New Tweed Valley Hospital-Mod-2 (SSD-9575-Mod-2)
Response to Submissions

The Department has also undertaken a preliminary assessment of the Modification Report and, in addition to the issues raised in submissions, requires that the matters at **Attachments 1** be addressed in full. Please provide a response to the issues raised in the submissions and the attachments to this letter by 18 January 2020.

RETAINING WALL SCHEDULE			
WALL REFERENCE	ORIGINAL SSD1 WALL REFERENCE	APPROX. LENGTH	PROBABLE MAX HEIGHT
RW01	RW04	*	*
RW02	RW01	250m	3.4m
RW03	RW02	60m	1.5m
RW04	RW02	124m	3.4m
RW05	RW06	67m	2.2m
RW06	RW03	48m	3.0m
RW07	N/A	25m	1.6m
RW08	RW06	28m	3.4m
RW09	N/A	40m	2.5m

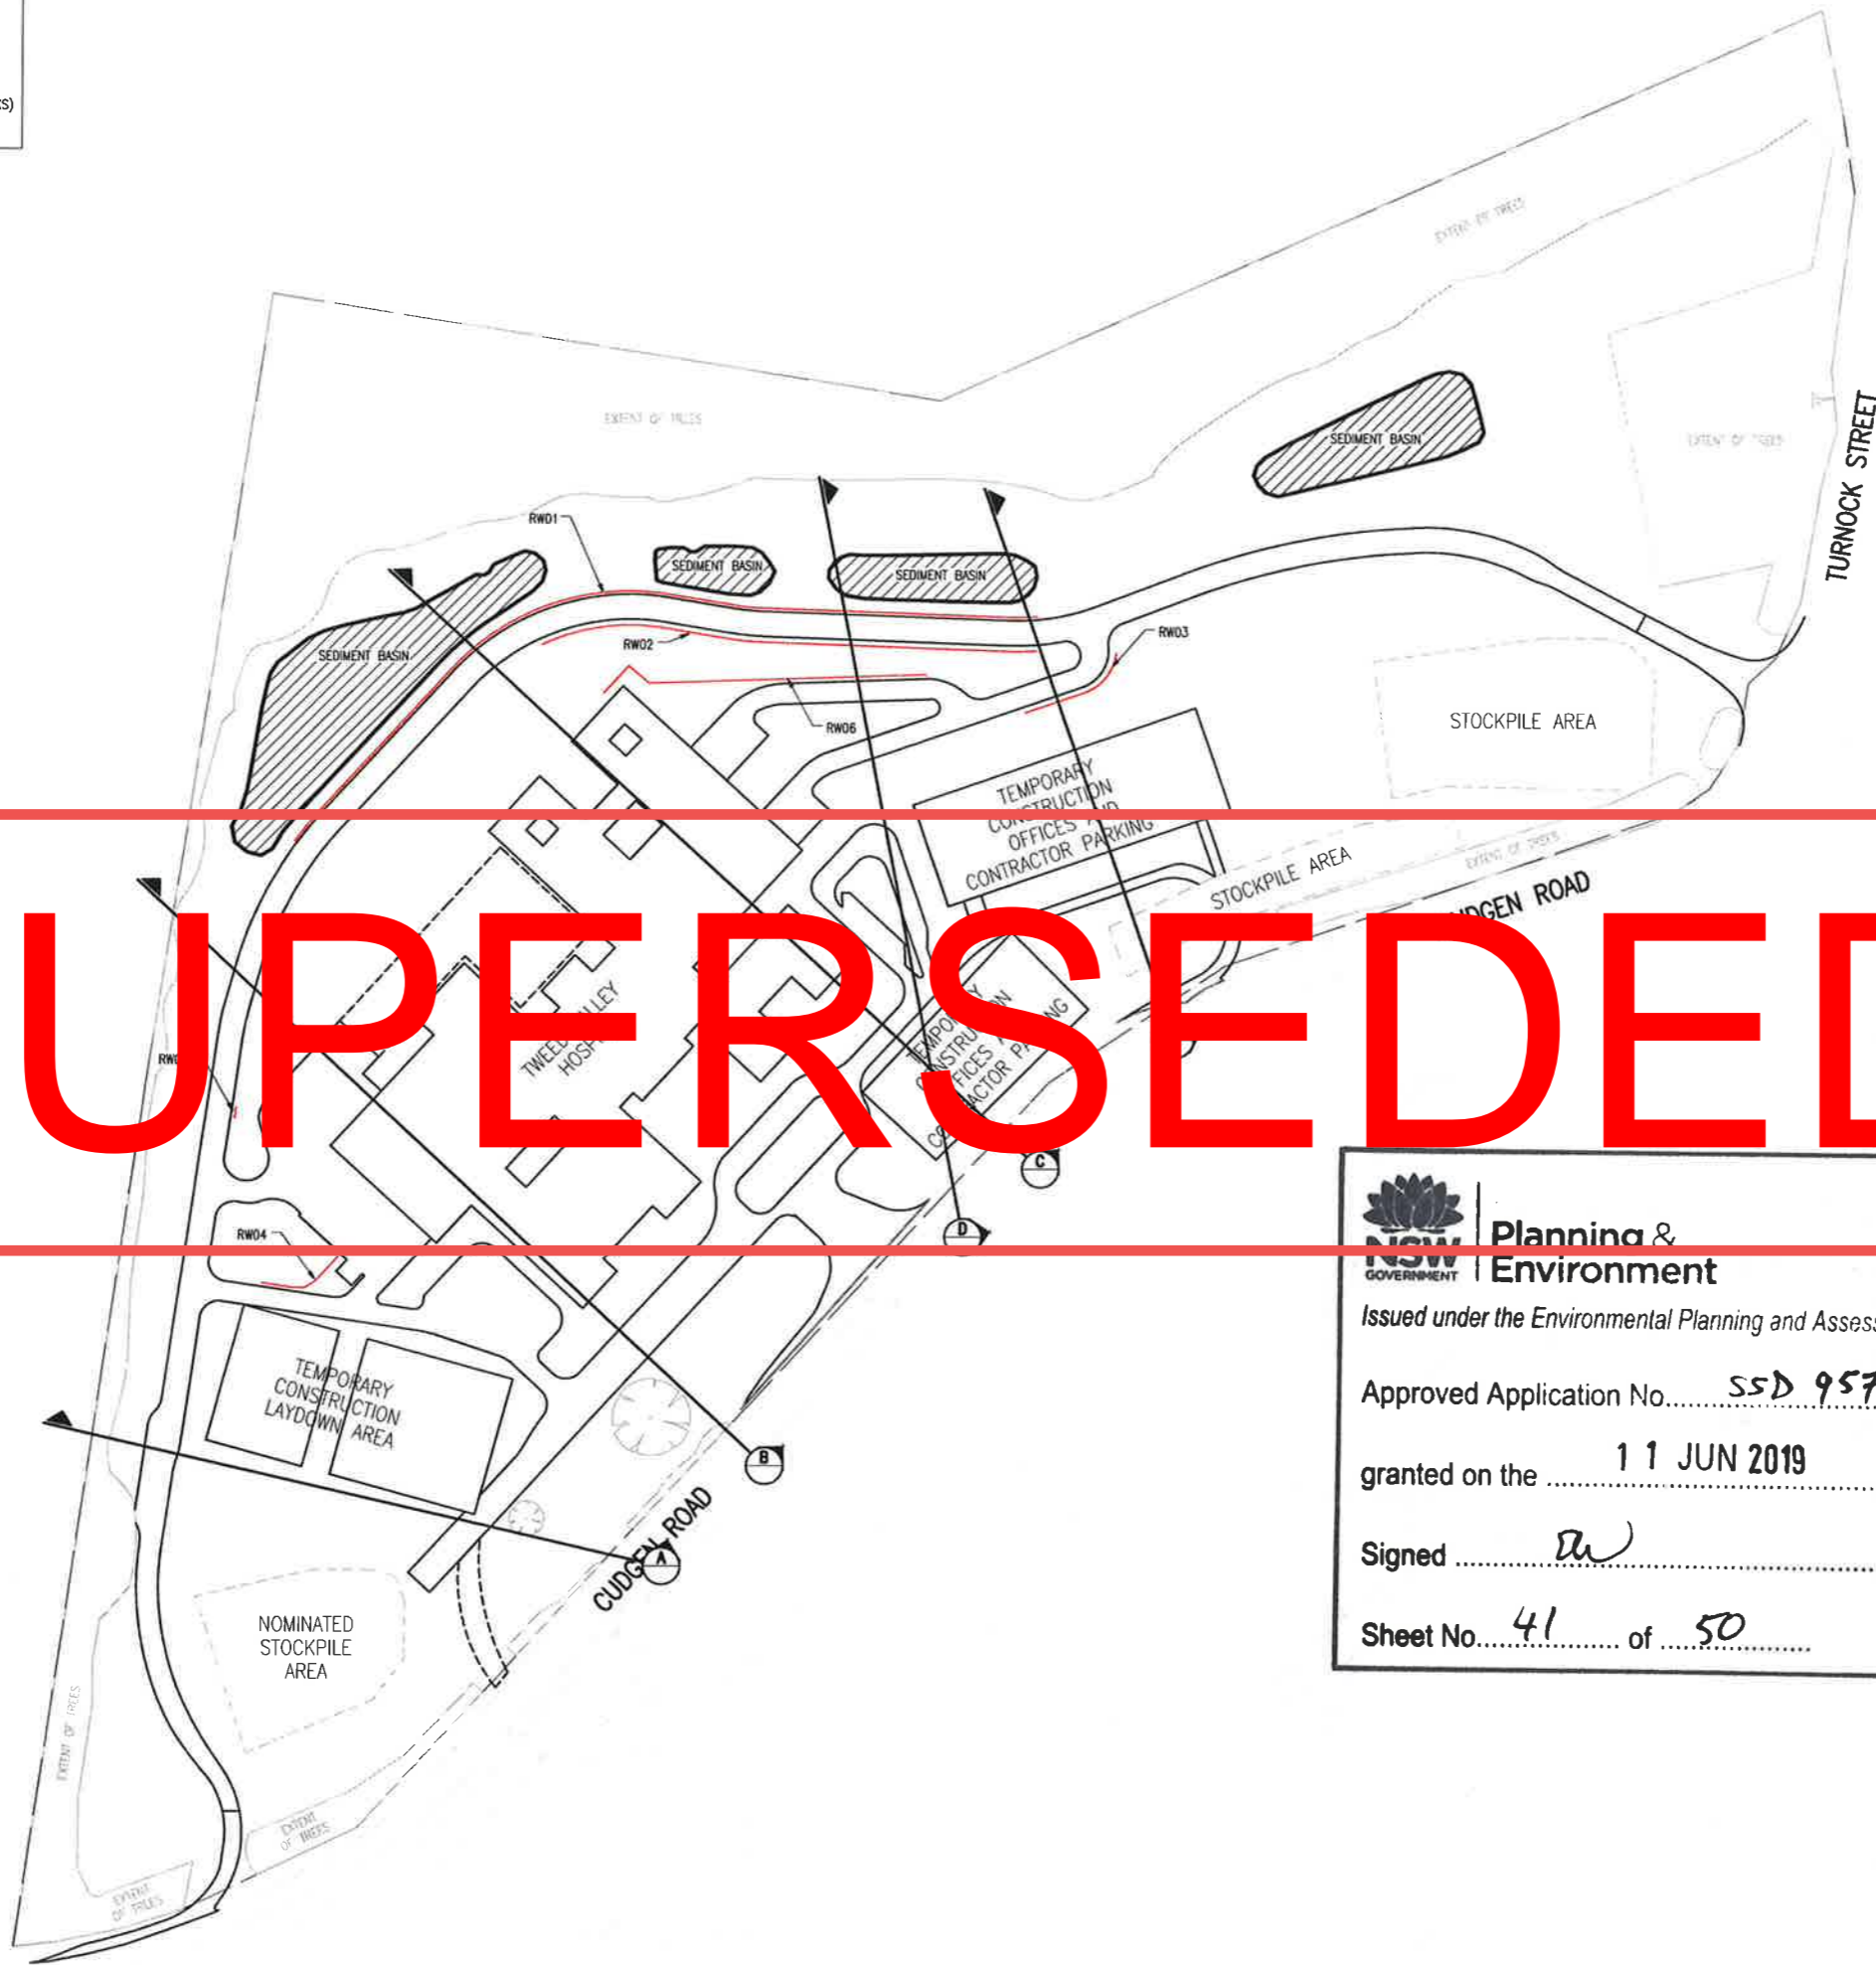
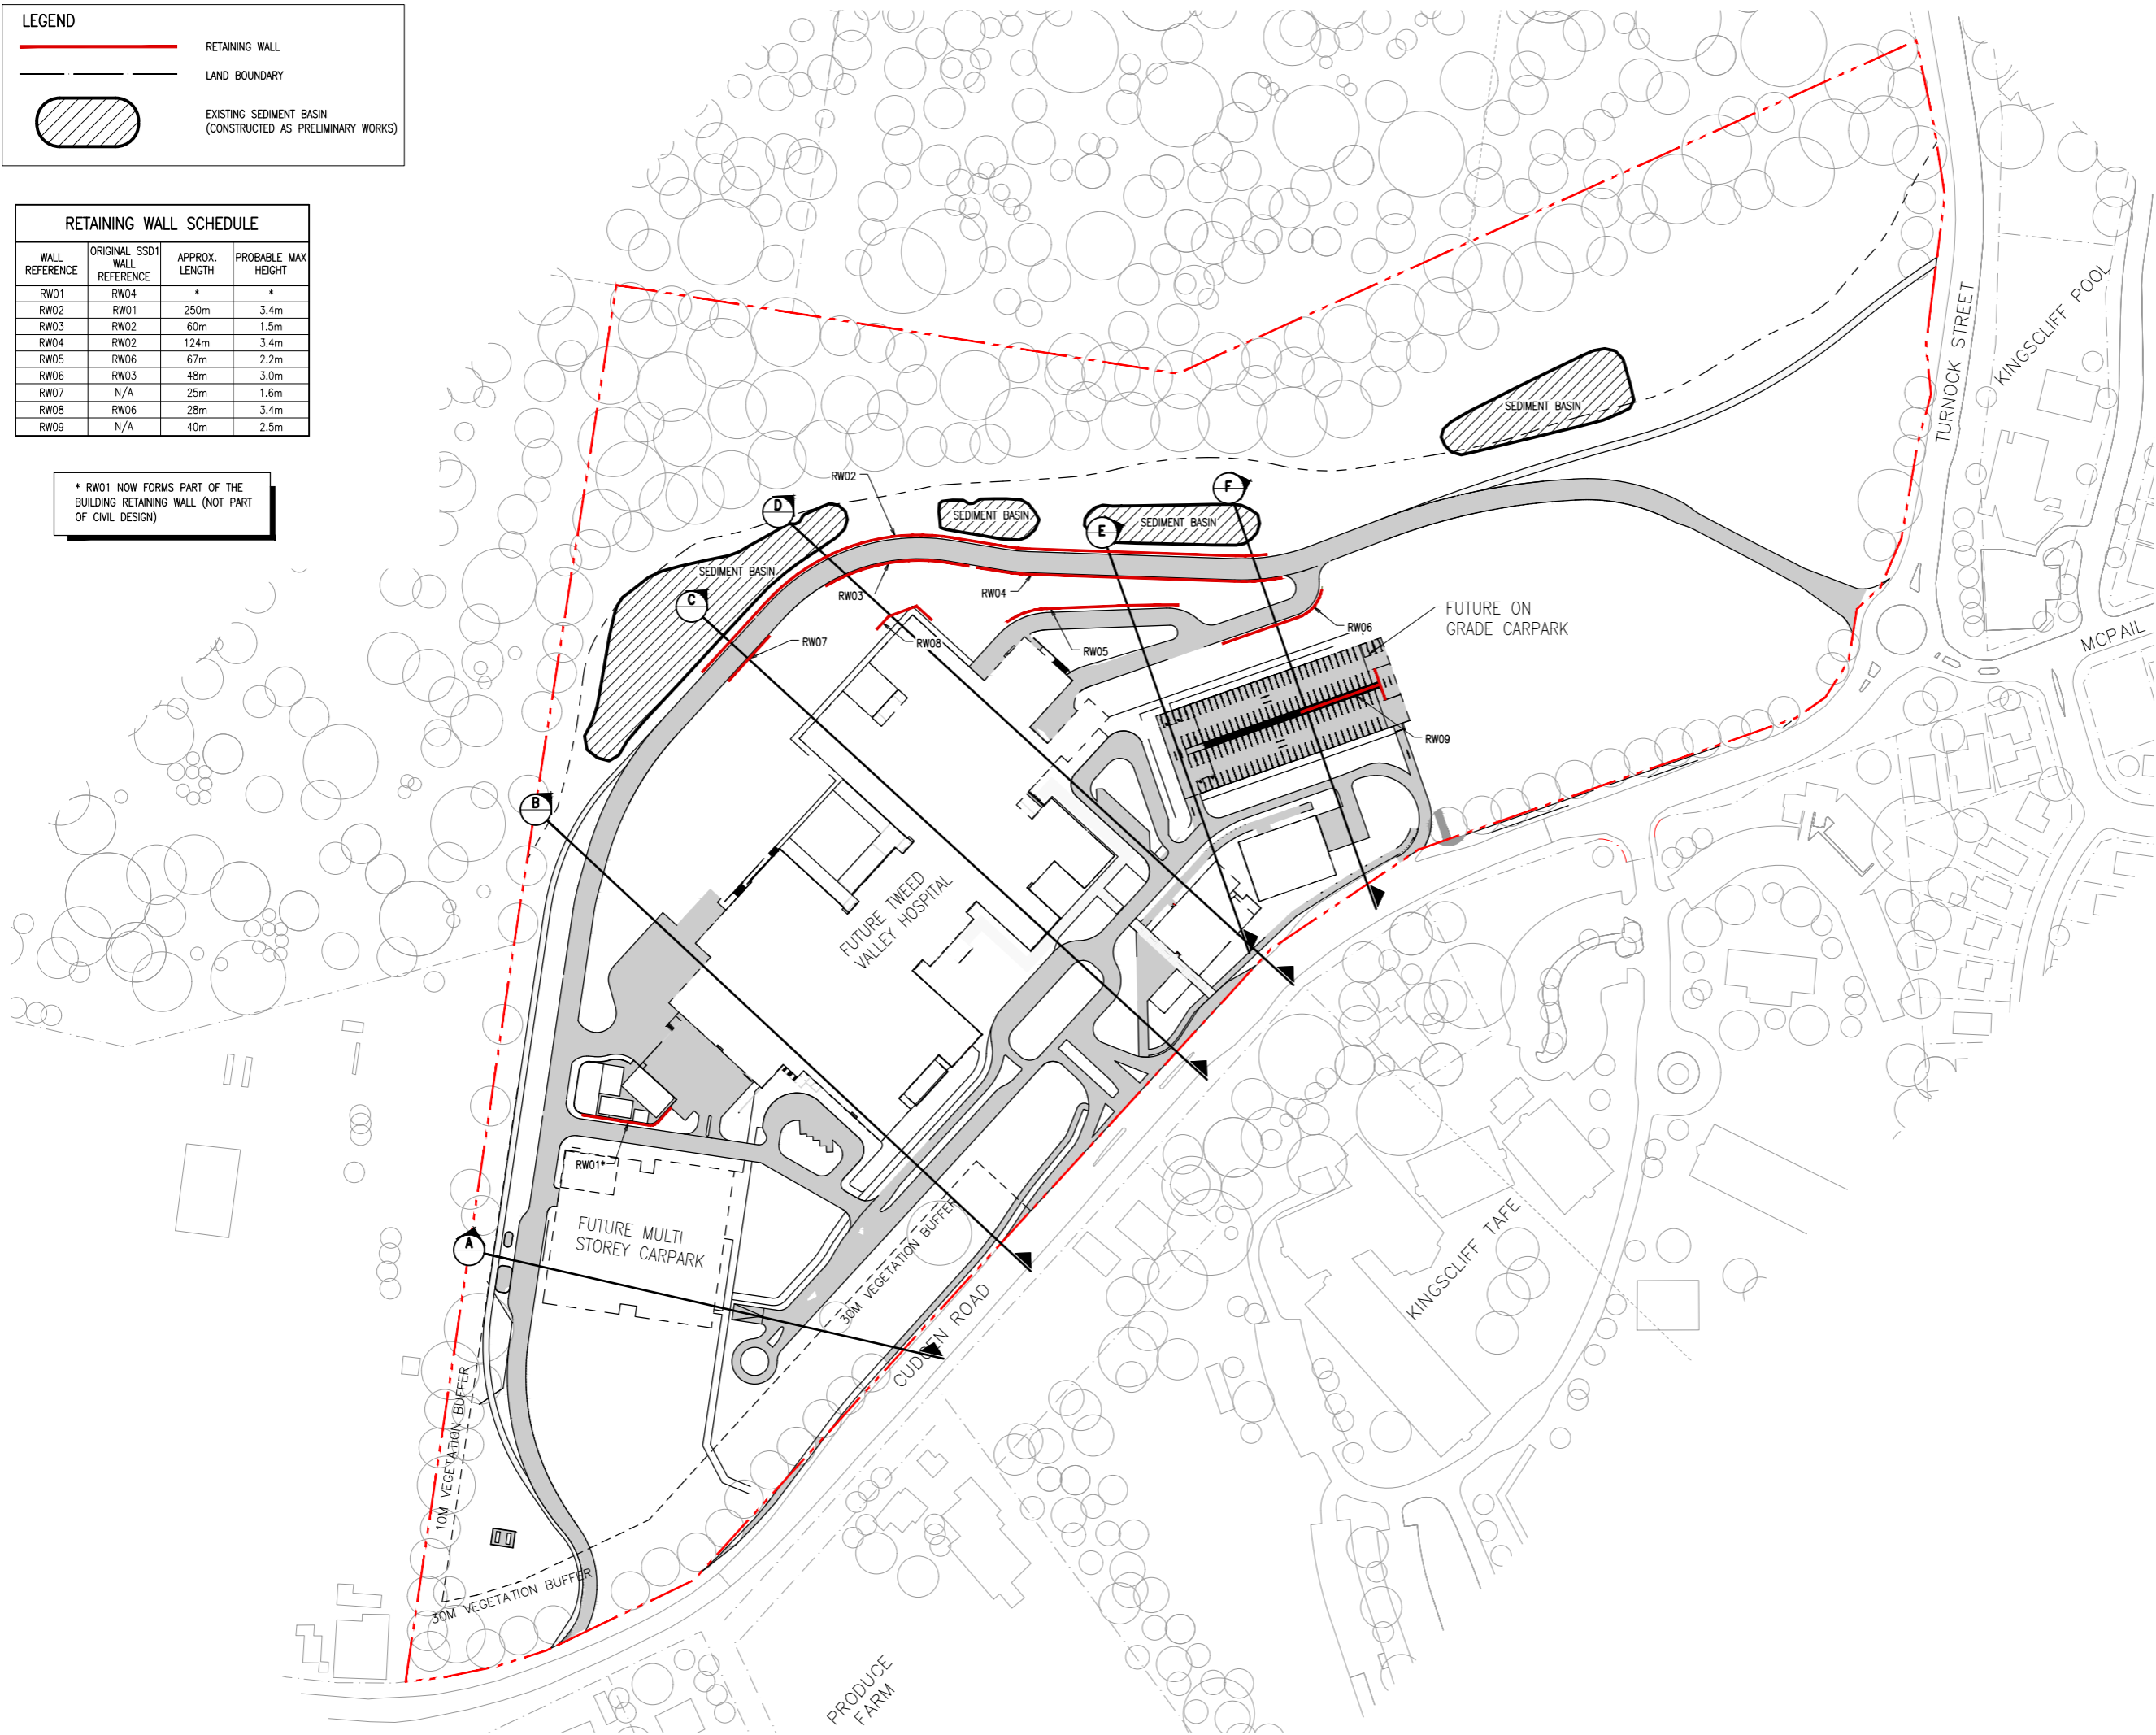
- The submitted plans indicate that the amended building envelope for the hospital and the car park would result in modifications to the volume of cut and fill that was previously approved under the Stage 1 works.
- Having regard to the above, an amended plan should be provided that identifies the modifications to the cut and fill volumes and the need for any further retaining walls (or variation to the heights of the retaining walls) within the site.
